May 20, 2020

Re: Community Baptist Church
3030 Todos Santos NW
Traffic Circulation Layout
Architect's Stamp 05-04-2020 (G10-D029)

Based upon the information provided in your submittal received 05-20-2020, the above referenced plan cannot be approved for Building Permit until the following comments are addressed. **Some of the comments were not/or partially addressed:**

MODIFIED RAMP STANDARDS (DRIVE PAD) PER COAST DWG 2425 NSF

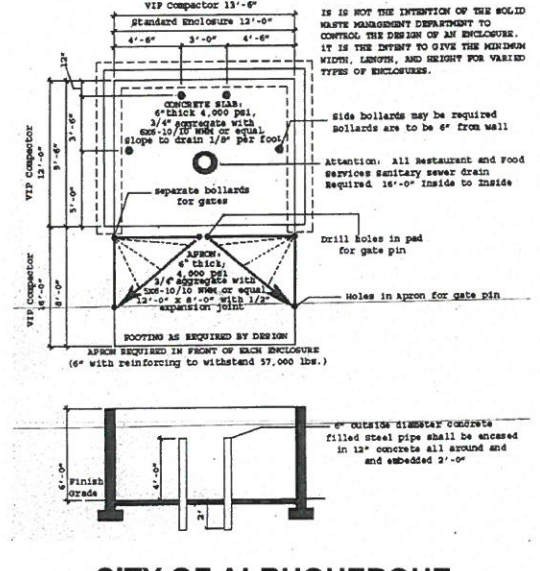
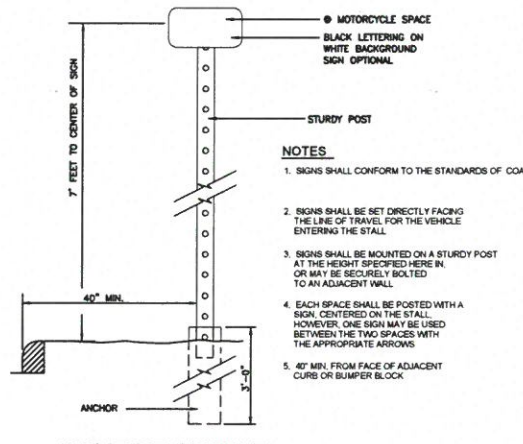
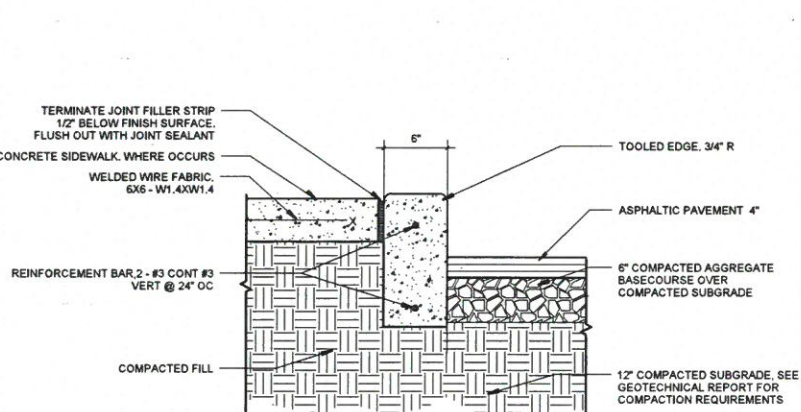
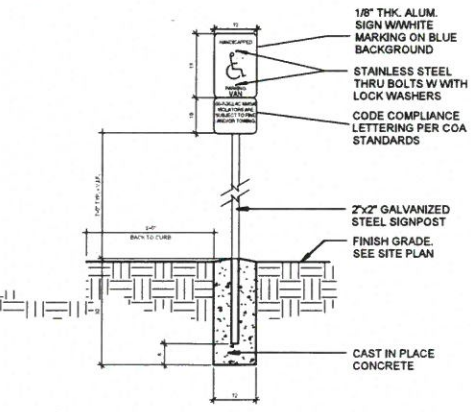
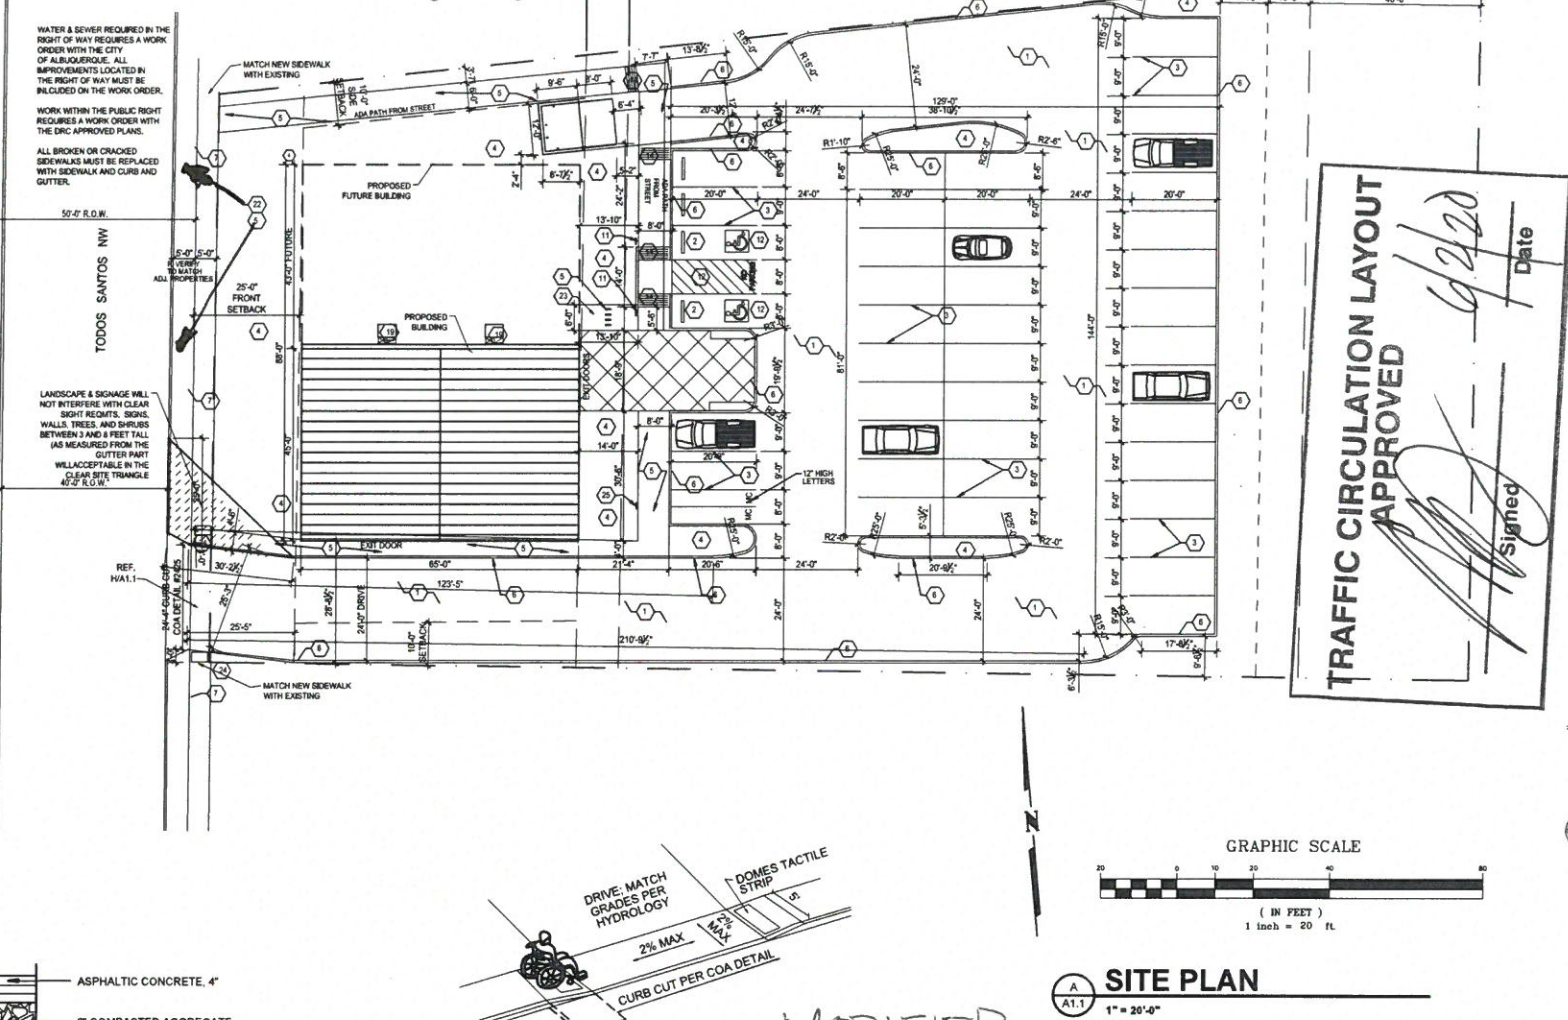
2. ADA curb ramps must be updated to current standards. Your keyed note 14 specifies 1:10 slope. This slope is 1:12 max and the landing is 1:50 max. Please reflect on your note 14.
